Colorado Springs, CO

Final Report - Corrections Required **Application No. ANEX-24-0005**

Description : Matrix Design Group on behalf of Colorado Springs Equities LLC is submitting a serial annexation petition for seven parcels and Land Use Plan/Rezoning exhibit for a portion of the subdivision known as Rock Creek Mesa.

Document Filename : Rock Creek Mesa Addition No 4_Annexation Plat_V3_5-13-24

# ANNEXATION PLAT ROCK CREEK MESA ADDITION NO. 4

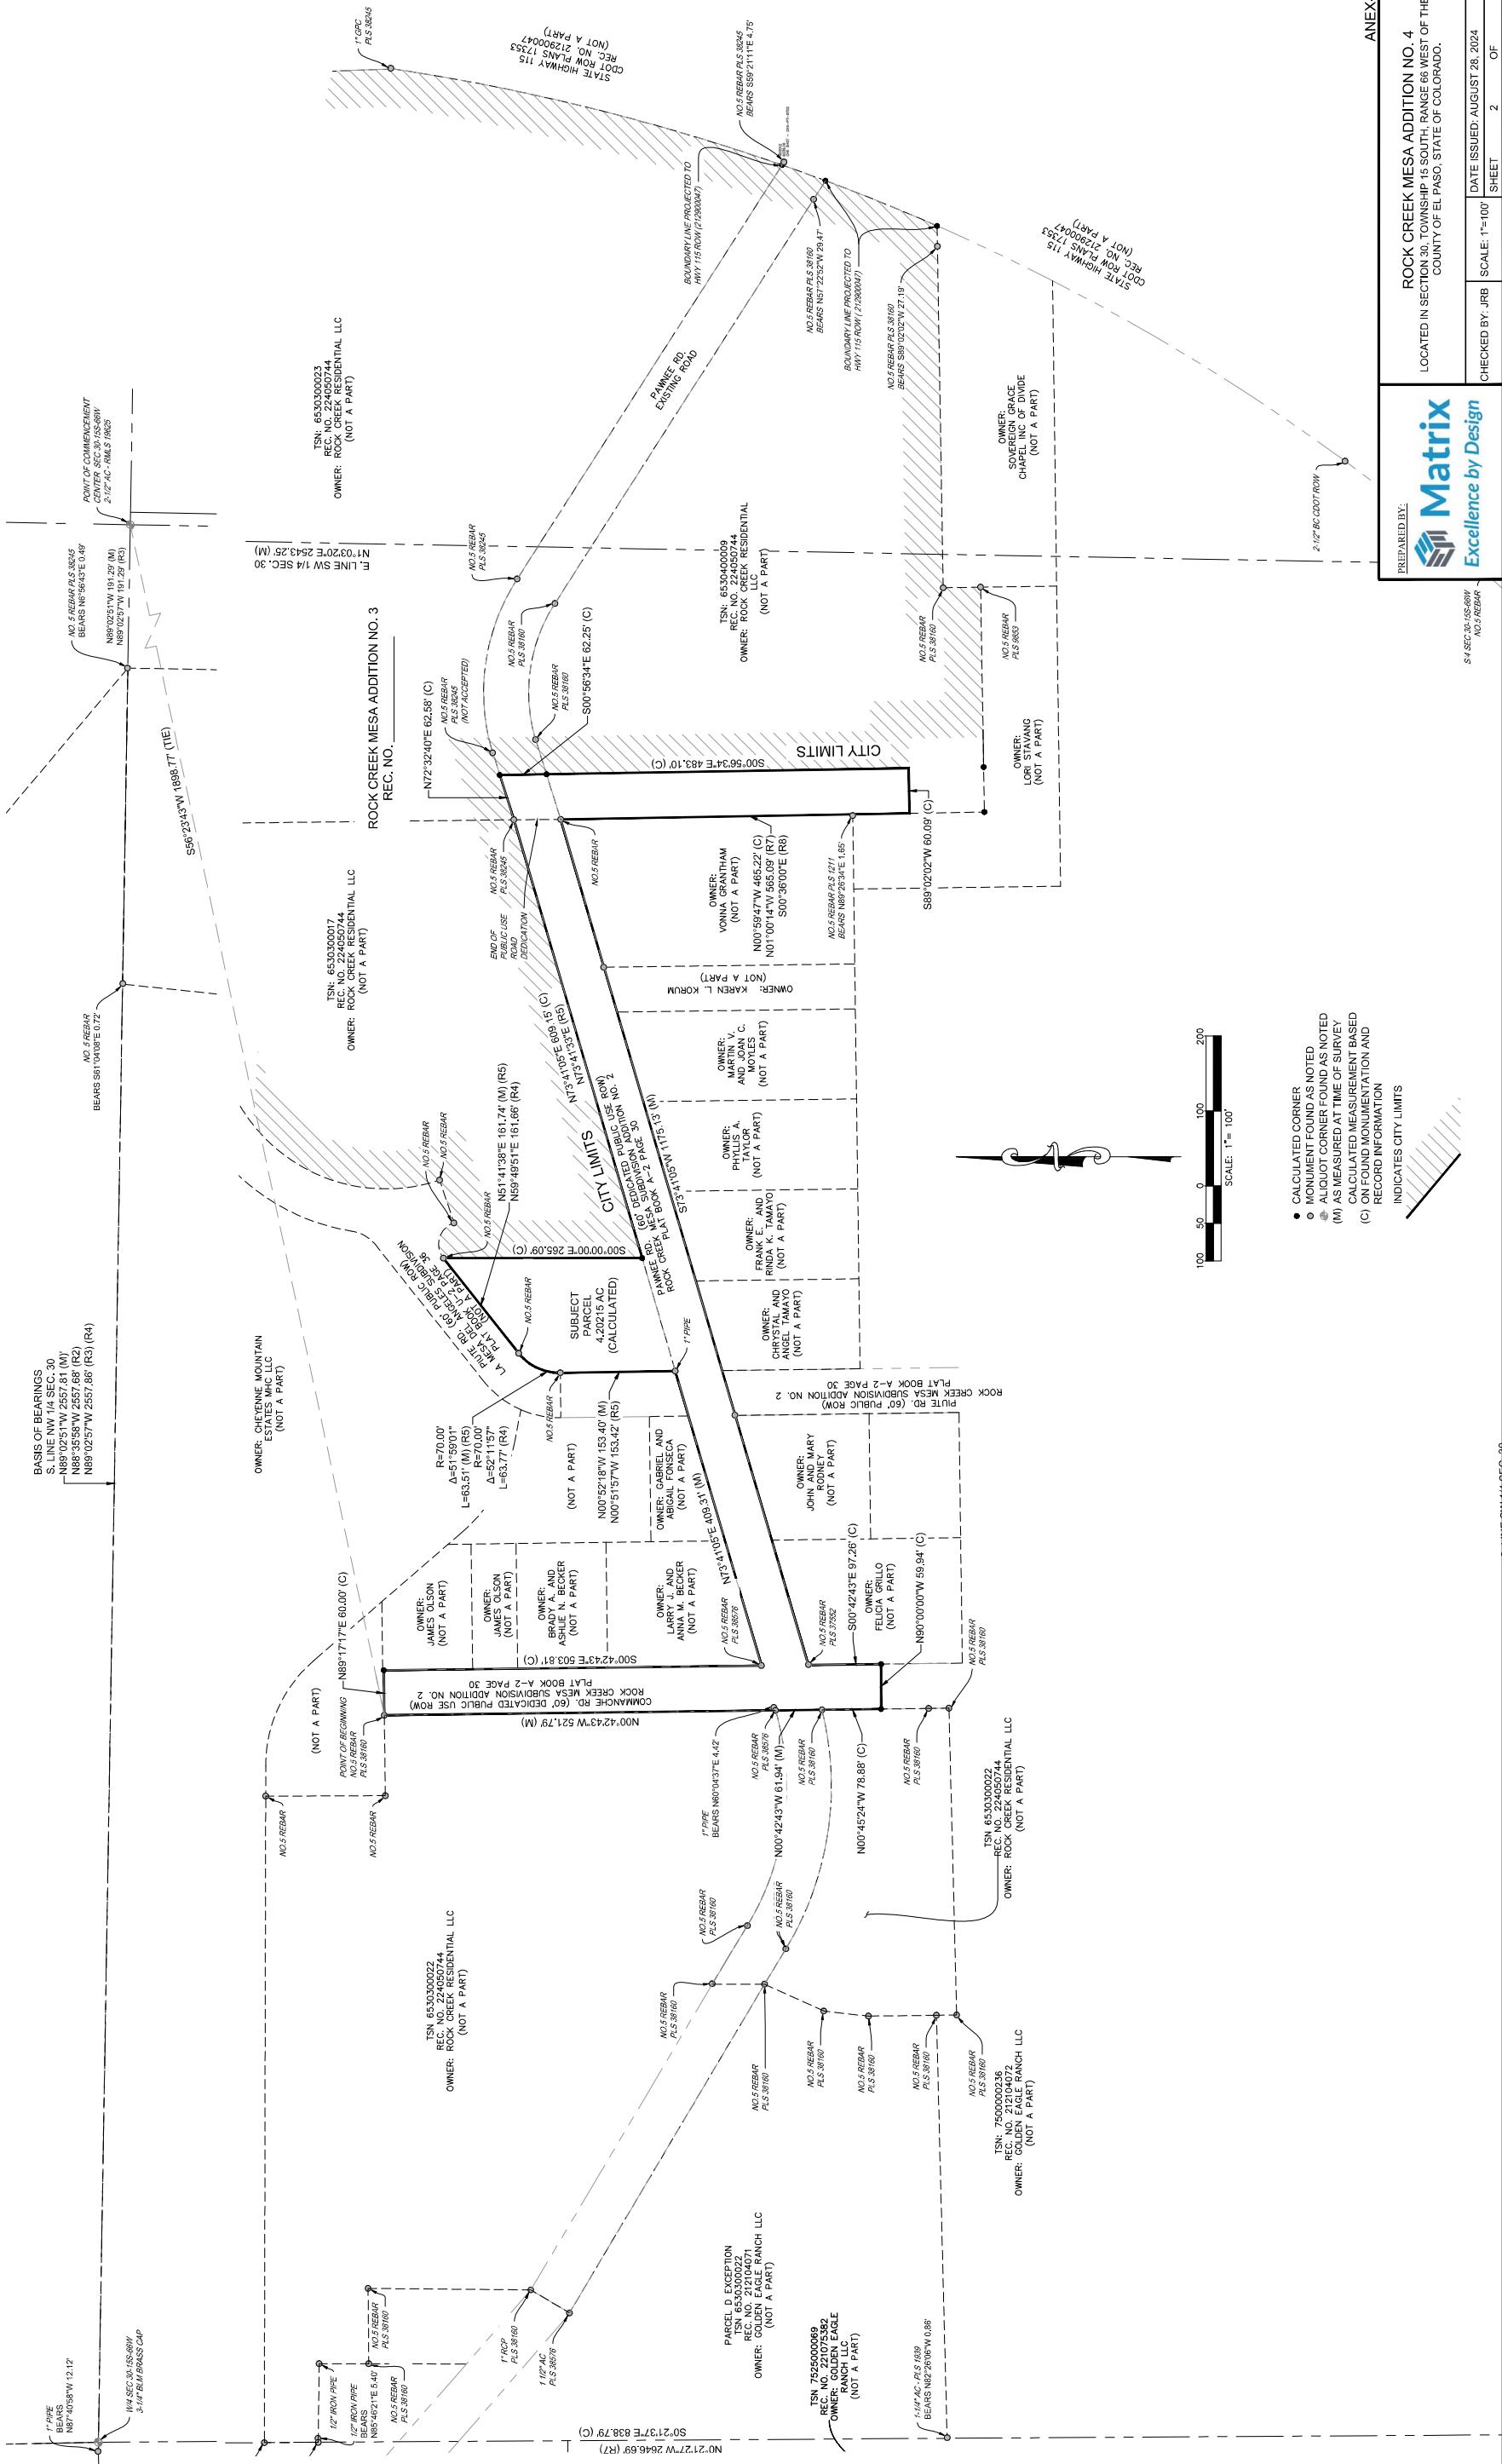
Comment ID	Page Reference	Reviewer : Department	Review Comments
41	2	Matthew Alcuran : Col Springs Utilities	Please add a general note to confirm the establishment of an appropriate easement(s) through a final plat for the existing OH electric (12.5kV Primary OH Conductor: CSU #12JL-1) running through portions of Addition Nos. 3, 5 and 6 or if it is to be relocated as part of the proposed future development.
44	1	Cory Sharp : Planning	please determine the name and title of the person signing and complete under owner and notary (so we are not waiting till the end and it be overlooked)
45	1	Cory Sharp : Planning	please update all legal descriptions accordingly with the tie poc/pob
49	1	Gabe Sevigny : Planning	Following Comment if from the School District: We only have one concern which is whether the developer is able to donate any land for an elementary school. 400 homes could generate 600 students - with approx. 350 elementary students and 250 secondary students. The existing schools on Fort Carson do not have the capacity to absorb that many elementary students. We typically need 12 acres or so for an elementary school. We may also need to add a preschool too. (Contact: Vergunst, Joanne jvergunst@FFC8.org) Note from Planner, this will need to be resolved prior to public hearing

Comment ID	Page Reference	Reviewer : Department	Review Comments
50	1	Gabe Sevigny : Planning	Per Surveyor comments, Pawnee Road has not been resolved, cannot move to petition acceptance or further public hearing until 100% addressed.

-	2	Cory Sharp : Planning	
-	2	Cory Sharp : Planning	
42	2	Cory Sharp : Planning	Book 375 at Page 497 does not solve the right-of-way issue, book and page appears to cross a portion of the area but does not appear to define the existing right-of-way. A meeting on 5/23/2024 with Wyatt Weiss discussed this and it has to be resolved prior to any resubmittal. Please check/revise accordingly and provide document along with any other information for said right-of-way
43	2	Cory Sharp : Planning	it appears that PLS 38160 has the right-of-way line approximately 30' further west, is there a survey by said PLS, have you contacted PLS in regards to possible conflict, they also might have information on right-of-way of Pawnee
46	2	Cory Sharp : Planning	please consider adding point of commencing to the center of section and adding the tie to the legal description. (please add that information on all the additions that are showing said information, the comment was not added to the previous additions, please add accordingly to all that it applies to)

Please add a general note to confirm the establishment of an appropriate easement(s) through a final plat for the existing OH electric (12.5kV Primary OH Conductor; CSU #12JL-1) running through portions of Addition Nos. 3, 5 and 6 or if it is to be relocated as part of the proposed future development.

It appears that PLS 38160 has the right-of-way line approximately 30' further west, is there a survey by said PLS, have you contacted PLS in regards to possible conflict, they also might have information on right-of-way of Pawnee
